Recommendation Report for Planning Permission for Works or Extension to a Dwelling

REF NO: BR/13/22/HH

LOCATION: 235 Hawthorn Road
Bognor Regis
PO21 2UW

PROPOSAL: Erection of two storey side extension and single storey rear orangery following the demolition of existing rear conservatory and side extension.

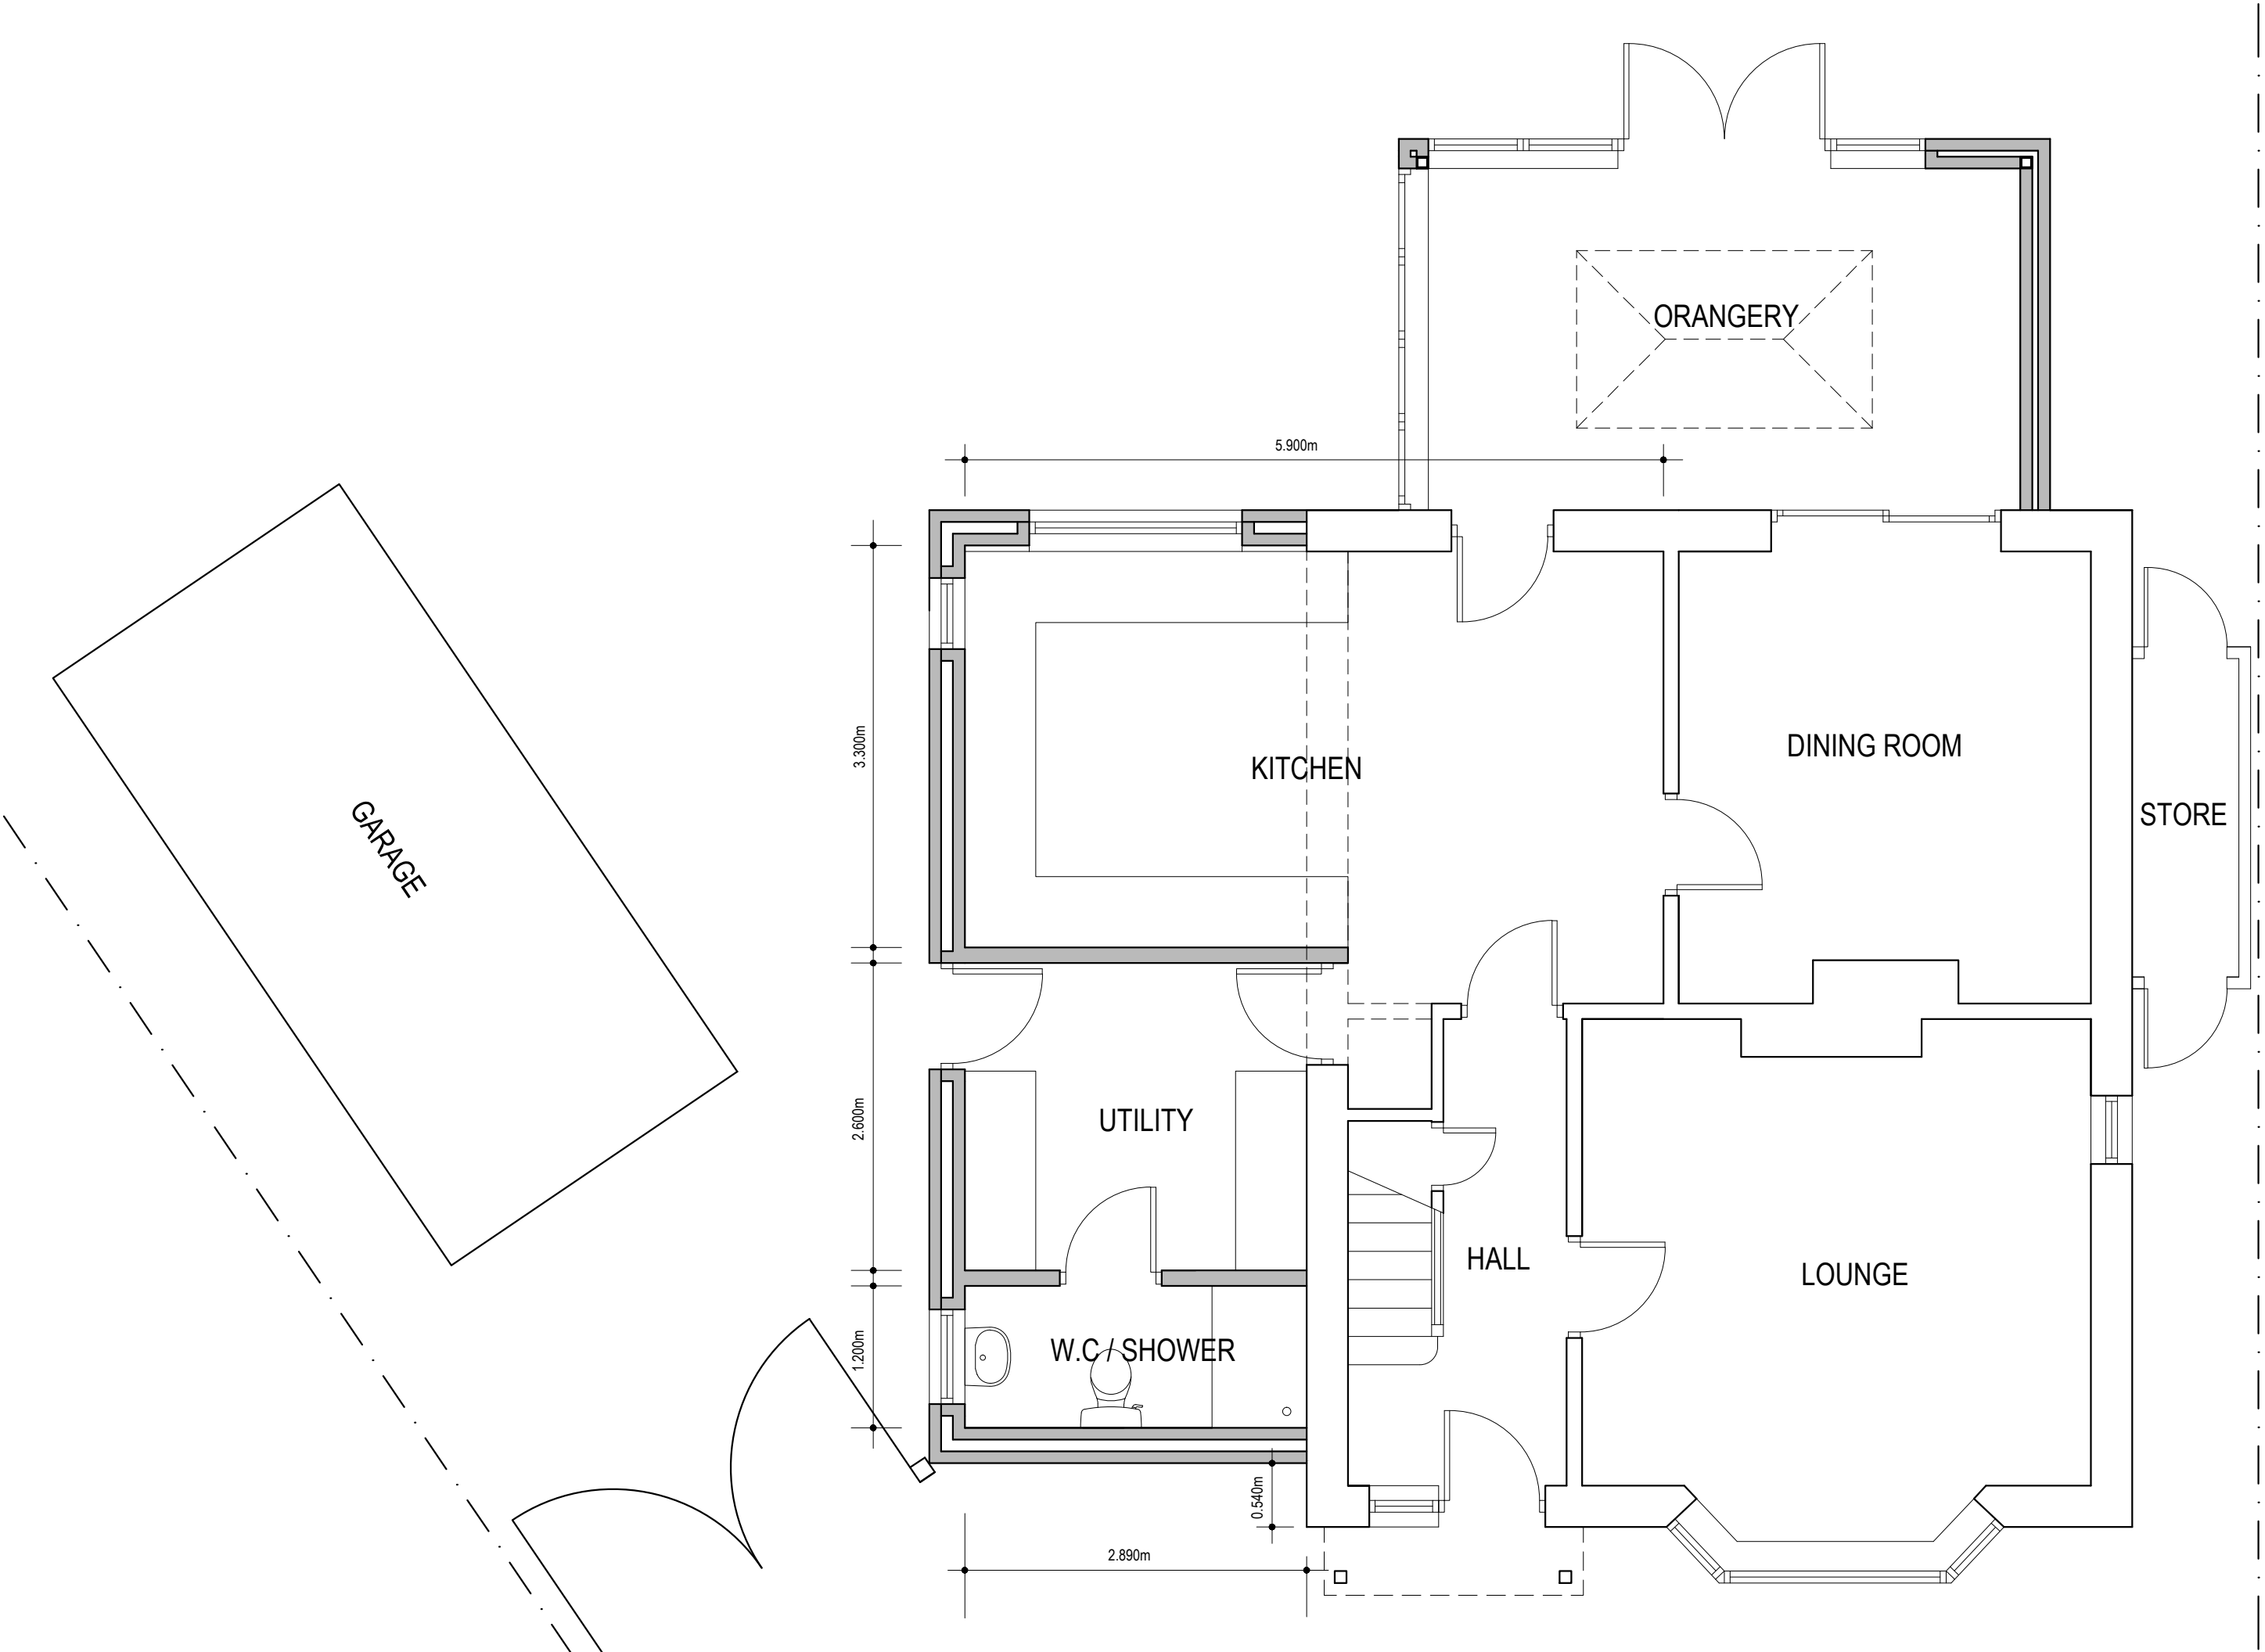
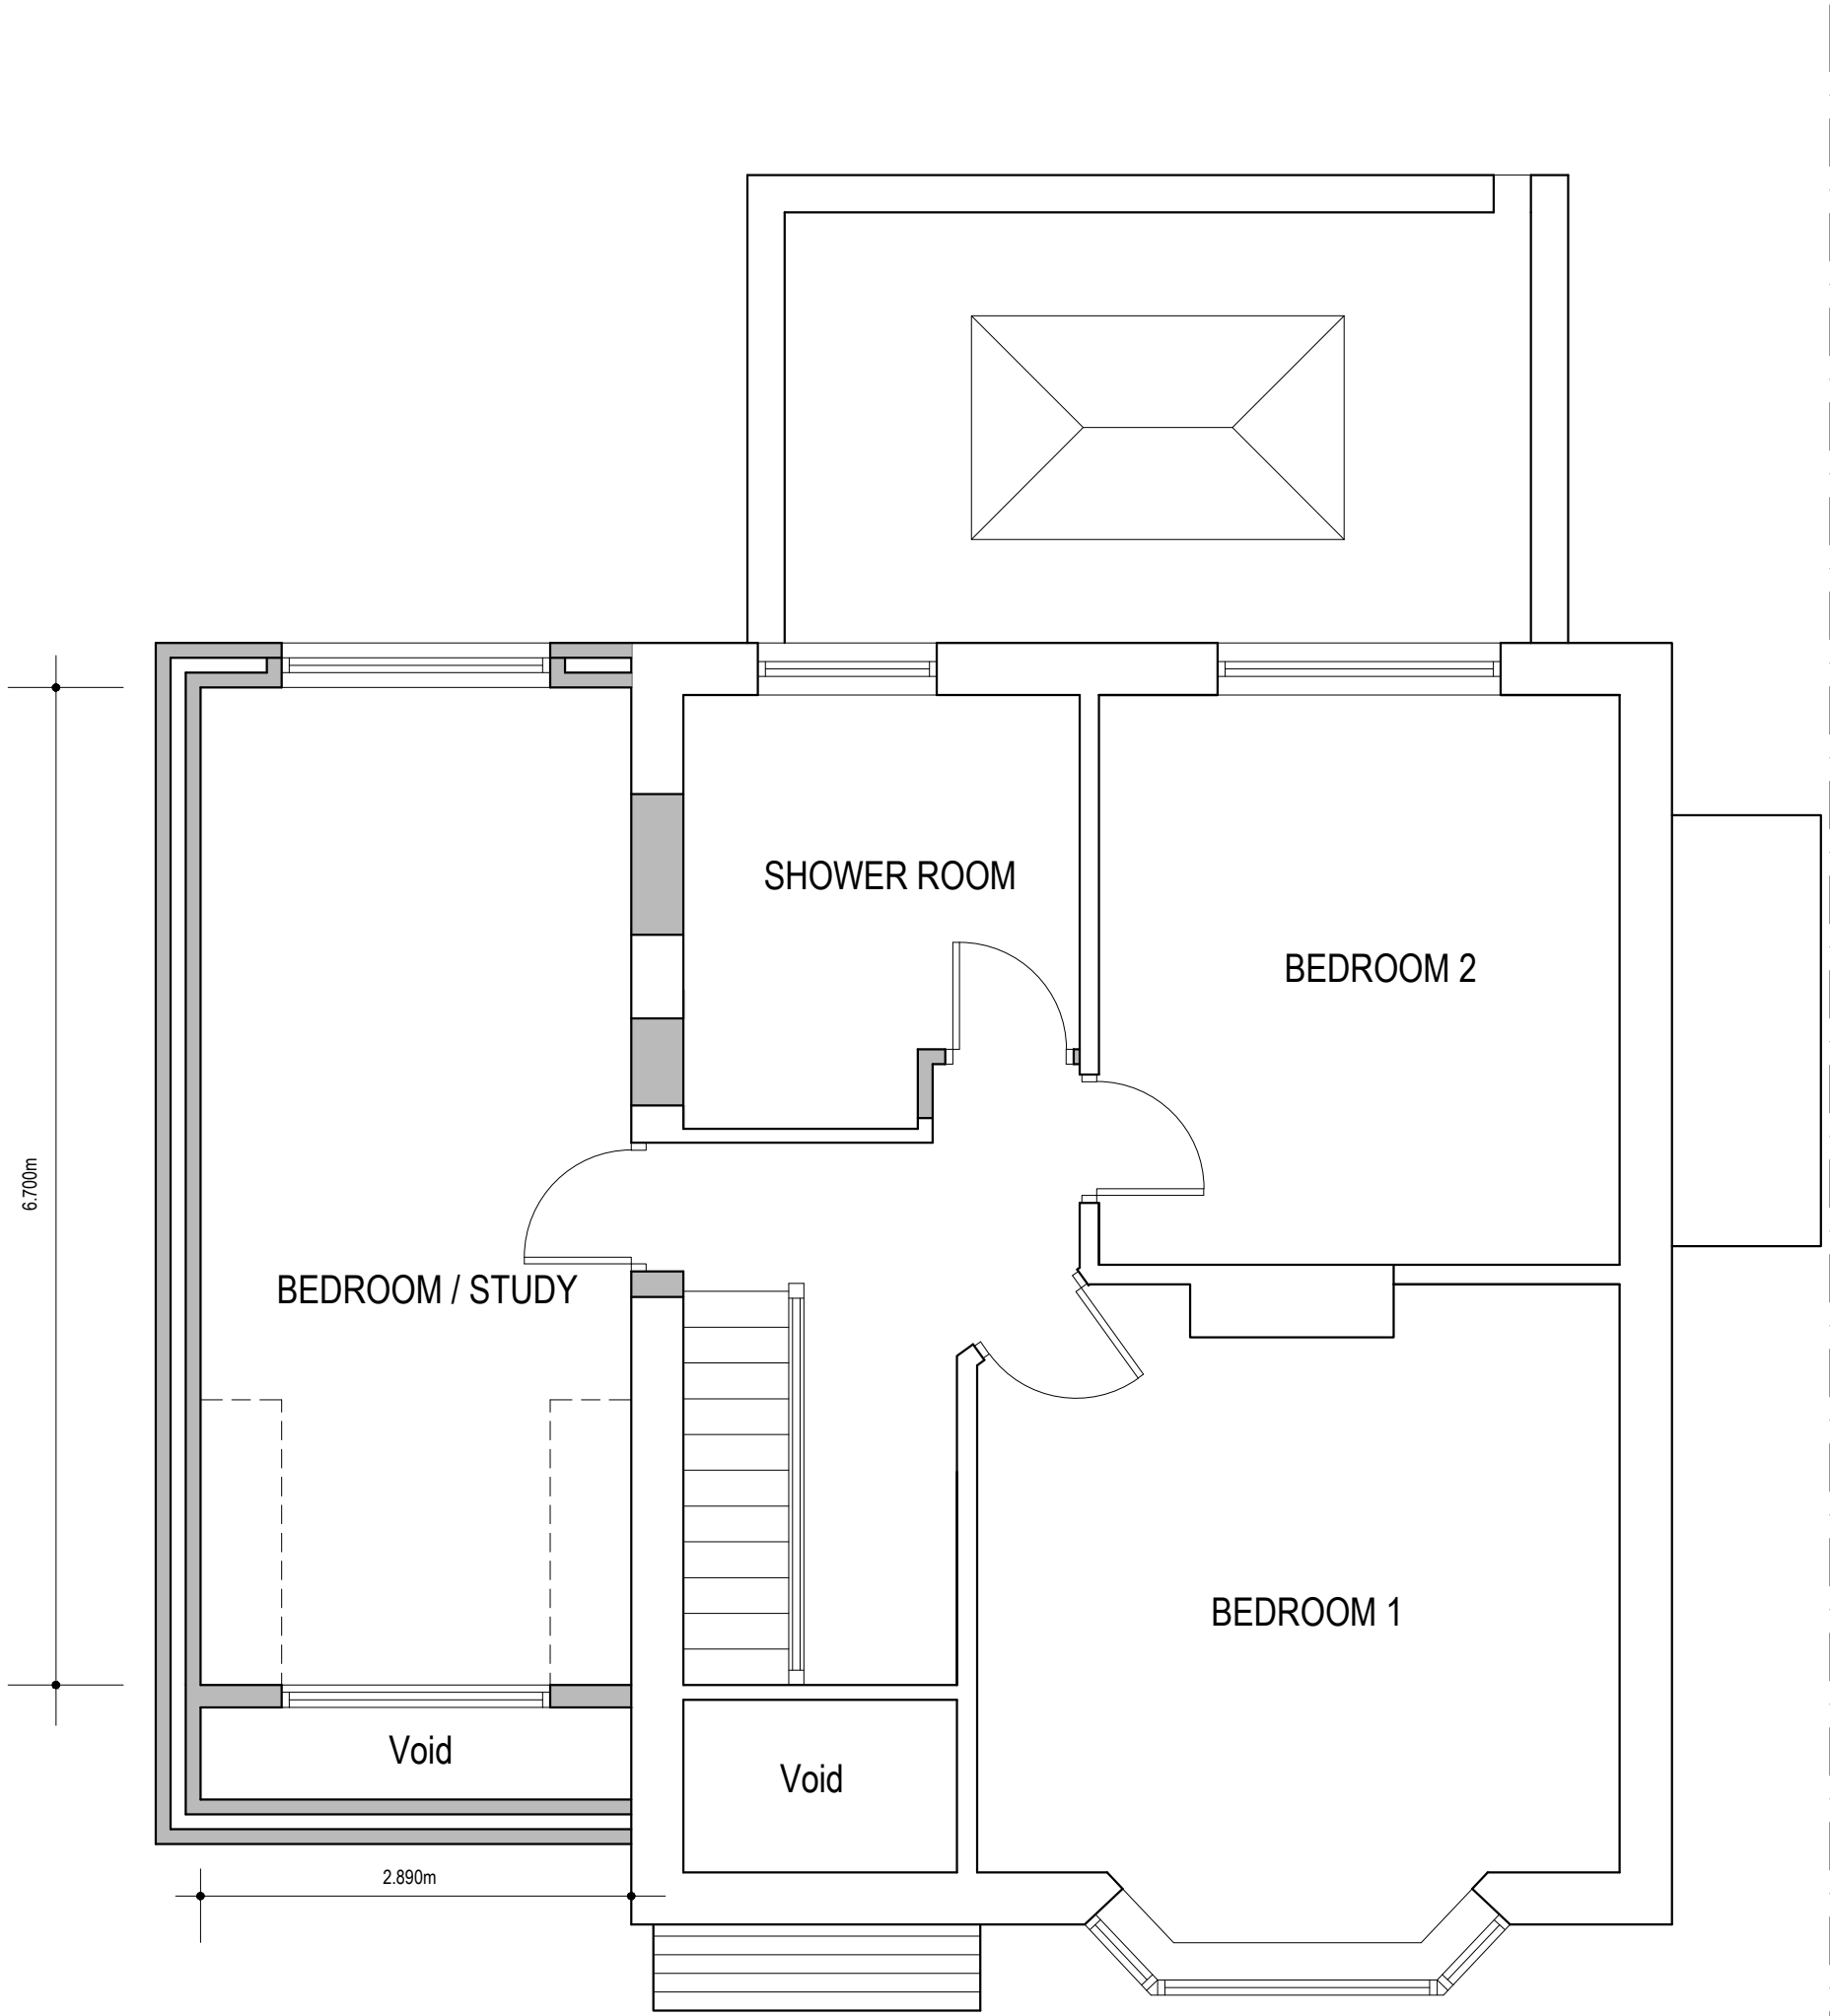
A two storey extension is proposed to the east side of the dwelling with a width of 3.15m. There is a single storey lean to which will be replaced. This runs along the full side elevation. The dwelling has a part cat slide roof with lower eaves to the front elevation. The proposal will continue the roof design and as such it appears well integrated with the host dwelling and appropriate in scale.

The front dormer has a pitched roof and is appropriate in scale to the roof slope. There is an existing gable roof to the front and the design is in keeping with that of the main dwelling.

The Arun Design Guide states ' In order to play a subservient role to the original building: the extension should be set down 1-1.5 metres for the ground floor and a minimum of 2 metres for the first floor ' The proposal does not comply with this, matching in height although appears well integrated. 'Extensions must not close important gaps in the street scene by leading to a terracing effect'. The proposal retains sufficient space to the boundary and with a public path running alongside it does not result in a terracing effect. Part M states: "Dormers should be a minor incident in the roof plane and made of sympathetic to the existing or original building materials'. ' Favours small scale dormer windows with pitched roofs over large, flat box-shaped designs'. The dormer complies with the guidance, featuring a pitched roof.

The two storey extension will have a width of 3.15m and run along the full side elevation, meeting with the rear building line and will match the ridge height of the dwelling. The extension retains a minimum of 4.6m to the side boundary and 8.6m to the rear. There is a public footpath which runs along the side boundary and with no neighbours to this side and acceptable separation to the rear, the two storey element will not give rise to adverse overbearing or overshadowing impacts.

To the ground floor is a conservatory which will be replaced with a single storey extension of the same footprint. This will have a depth of 3.1m and a flat roof height of 3m which increases to 3.5m with the addition of a roof lantern. This is set in 1.75m from the south western boundary and does not appear to interest a 45 degree angle when drawn from the closest windows to the boundary . As such it does not result in adverse overbearing or overshadowing upon this elevation.

The two storey proposal will result in an additional two first floor rear facing windows serving a bathroom and a bedroom. The windows, specifically the bedroom window will provide additional overlooking upon the property to the rear at No.32. The bathroom window is in the existing building so may constitute permitted development and not require planning permission.

There is 19.5m separation from the window to the rear elevation of No.32 and whilst slightly short of the guidance, it is not deemed significant in which a refusal is justified. There is an existing rear facing window and views would be similar to that which are achievable from the existing bedroom. Some views may be possible to No.30 however due to the separation and the angle, views would not be significant.
